CITY OF ALBUQUERQUE

November 16, 2016

Re: Campbell Brewery -4814 Hardware NE
90-Day Temporary Certificate of Occupancy- Traffic Certification Only
Architect's Stamp dated 08-07-15 (F17D097)
Certification dated 11-16-16

SITE PLAN

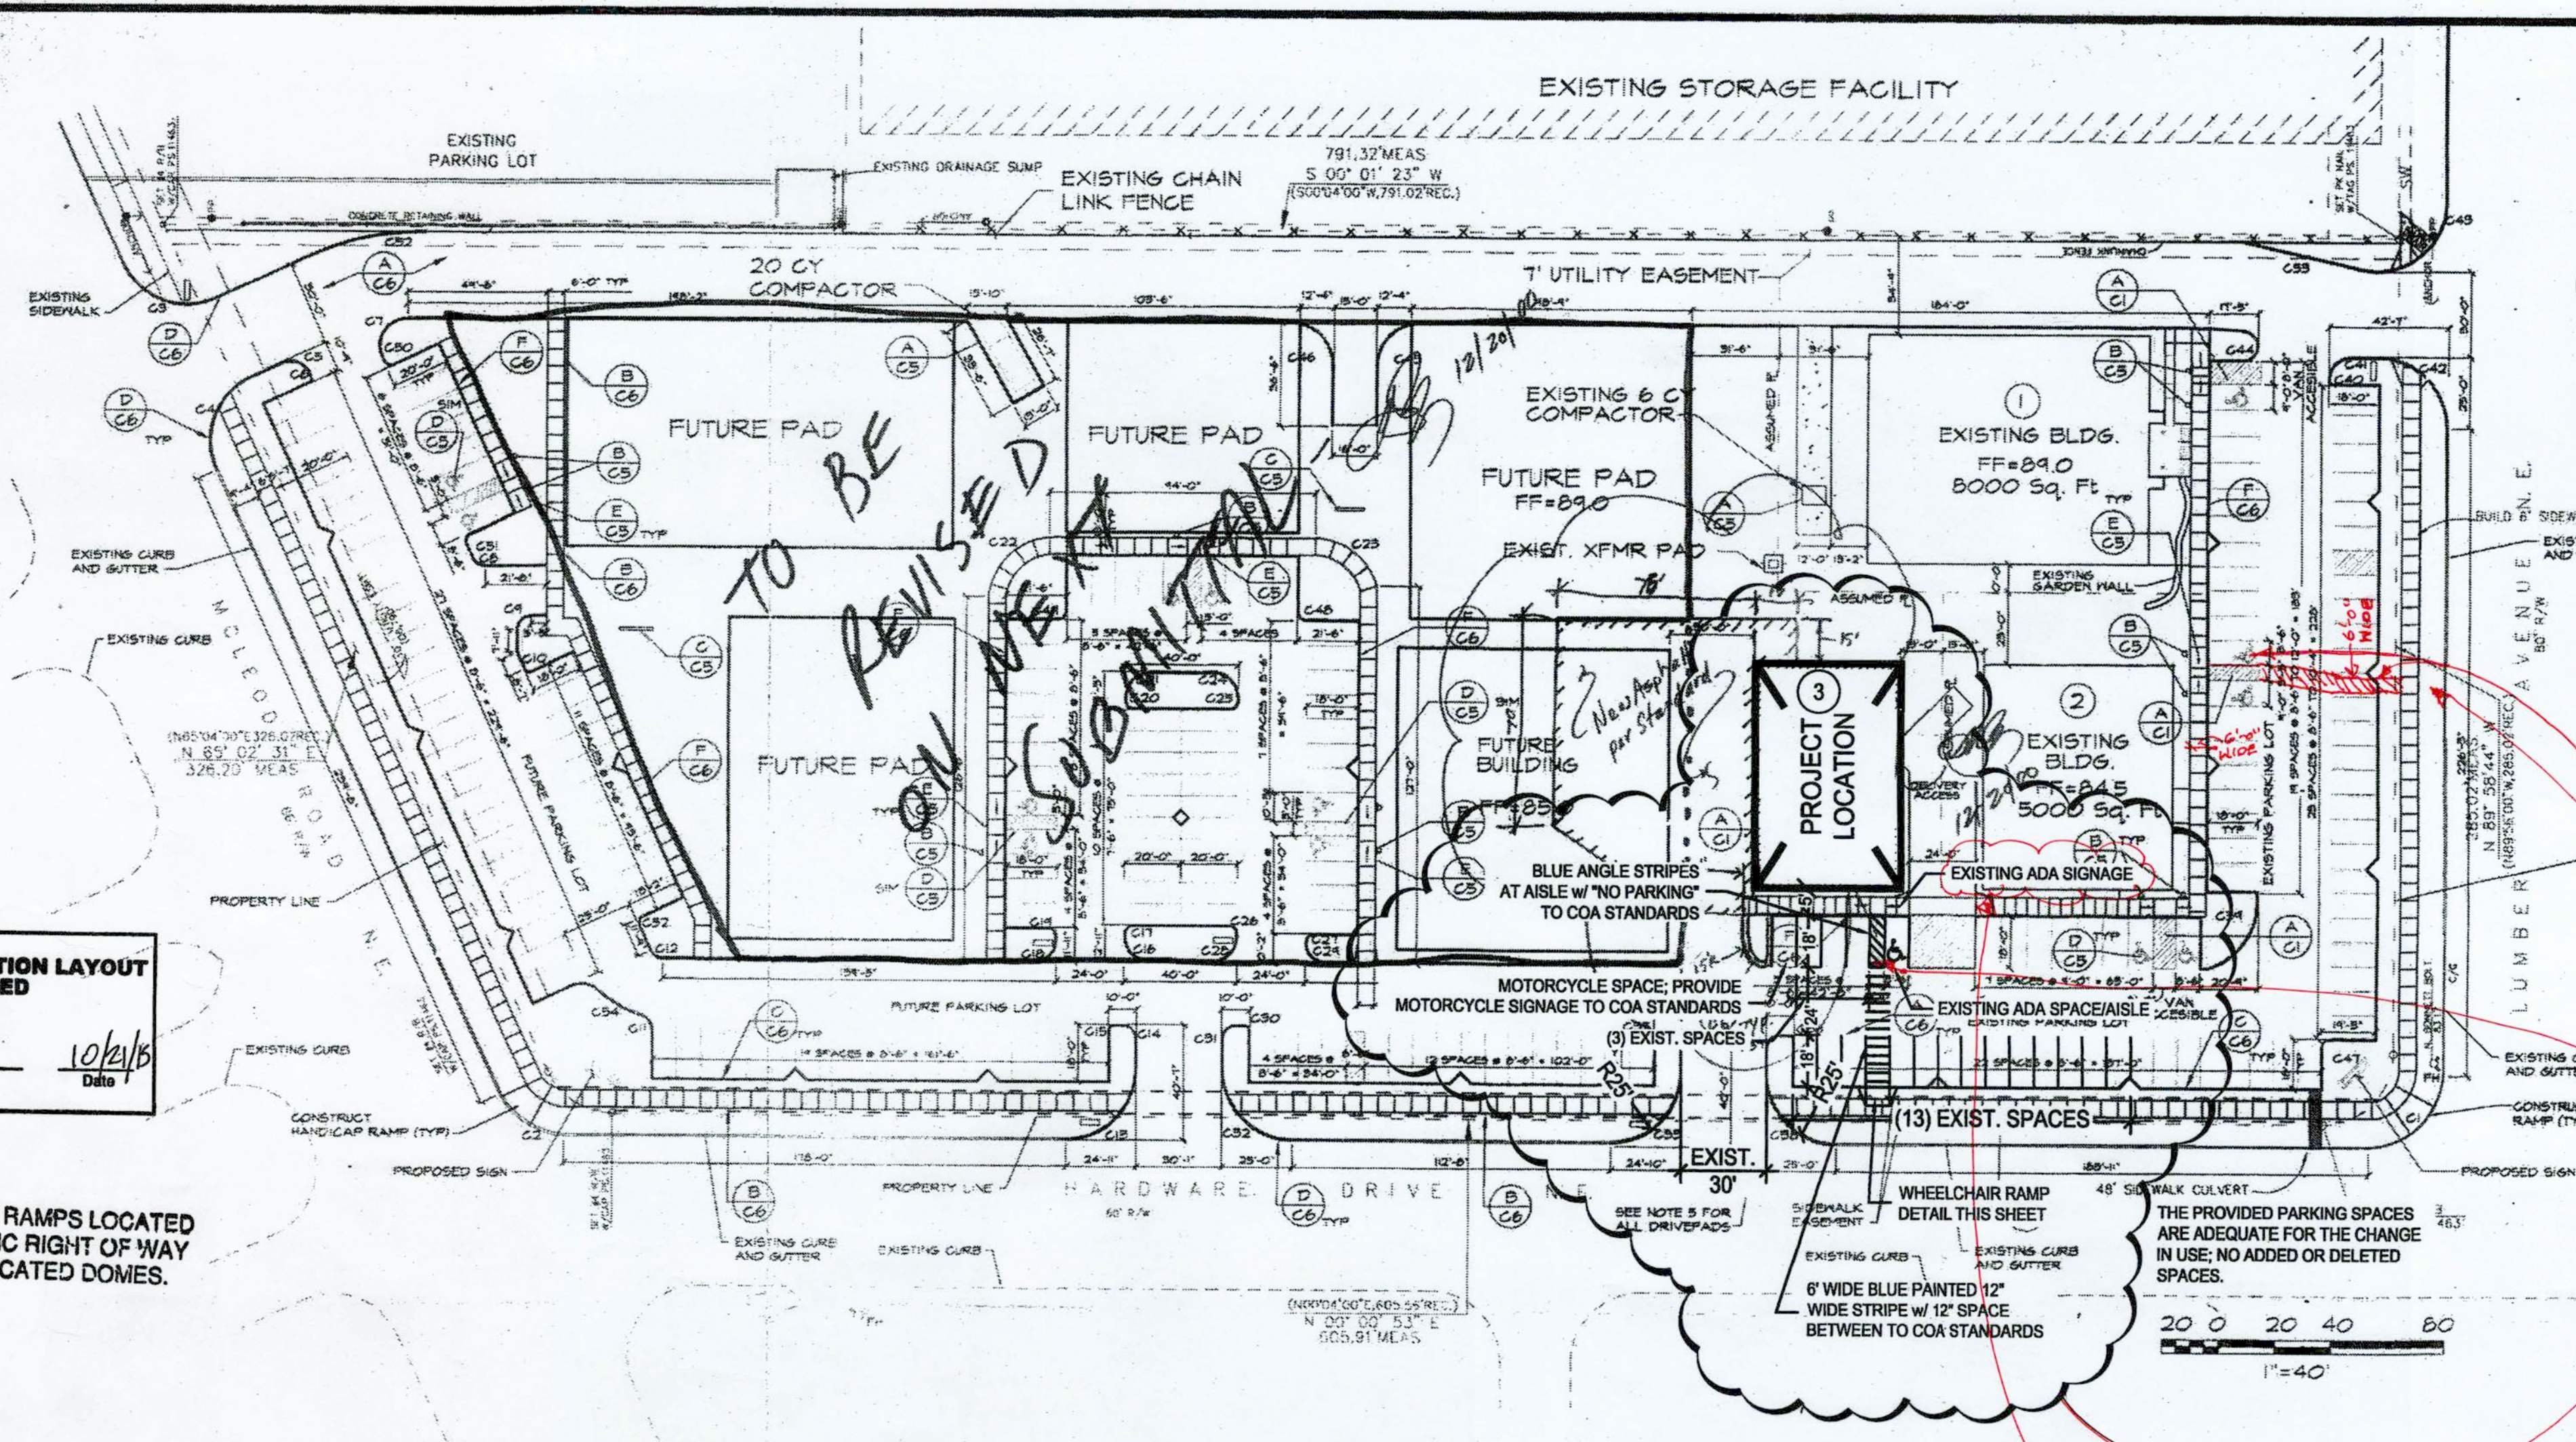
1. The 6' pedestrian access to the site must be constructed and striped per the approved TCL.
2. The approved and stamped TCL, with any changes drawn in red.
3. Transportation Certification letter on either the plan or applicants letterhead.
4. A Drainage Transportation Information Sheet (DTIS)
5. Send an electronic copy of your submittal to PLNDRS@cabq.gov.
6. A site inspection will be completed.

1. THE PUBLIC SIDE WALK ACCESS
2. THE CURB CUT
3. THE STRIPING FROM THE PUBLIC SIDEWALK ACCESS ACROSS THE PARKING LOT.
4. THE OWNER REQUESTS TEMP C.O. FOR 90 DAYS IN ORDER TO GET THE SITE INTO COMPLIANCE WITH THE APPROVED TCL.
